Flood Management & Drainage Consultation

Consultation on Application Number: 2016/92812

Address: Victoria Works, Fisher Green, Honley, Holmfirth, HD9 6DP

Proposal: Demolition of industrial building and erection of 17 No. apartments with integral garages and associated parking

Drainage Layout

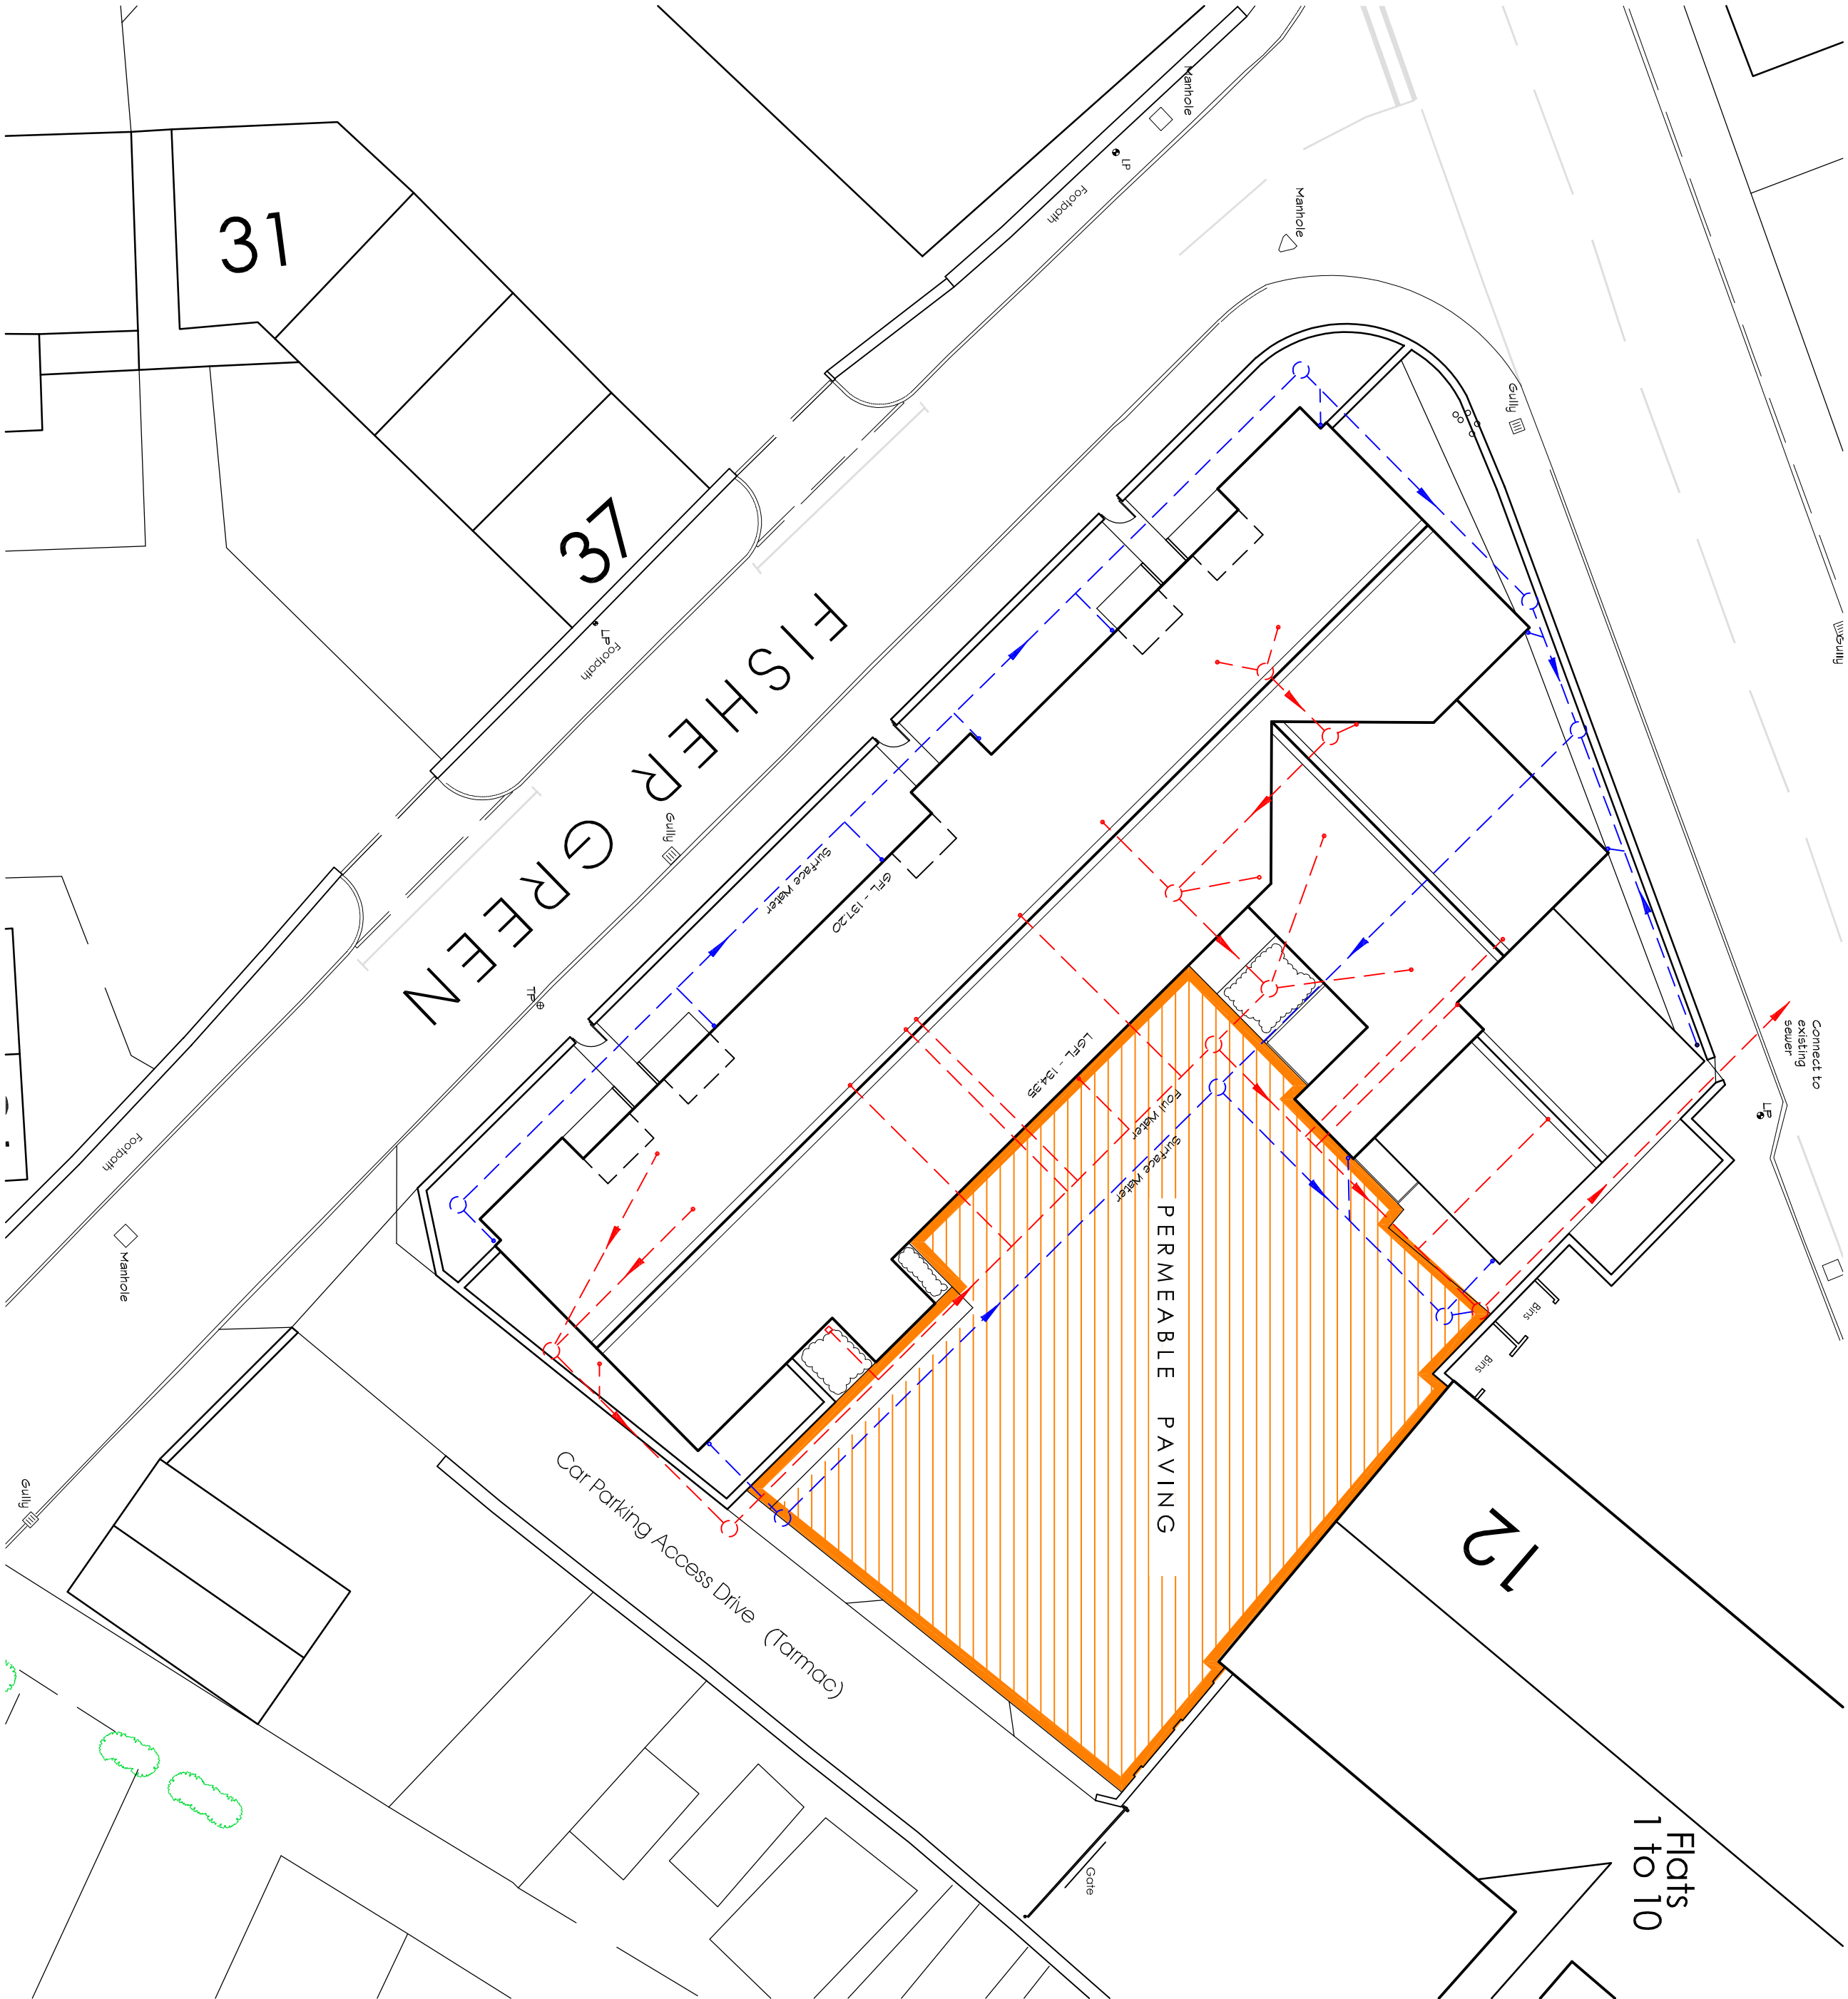
Development shall not commence until a scheme detailing separate foul and surface water drainage, (including outfalls, acceptable discharge rate to be agreed with the Lead Local Flood Authority, plans and longitudinal sections including appropriately sized attenuation, hydraulic calculations, existing drainage to be maintained/diverted/abandoned) has been submitted to and approved in writing by the Local Planning Authority. None of the dwellings shall be occupied until such approved drainage scheme has been provided on the site to serve the development or each agreed phasing of the development to which the dwellings relate and thereafter retained throughout the lifetime of the development.

There shall be no new buildings, structures or raised ground levels within 3 metres either side of the centre line of the culverted watercourse within or along the boundary of the site.
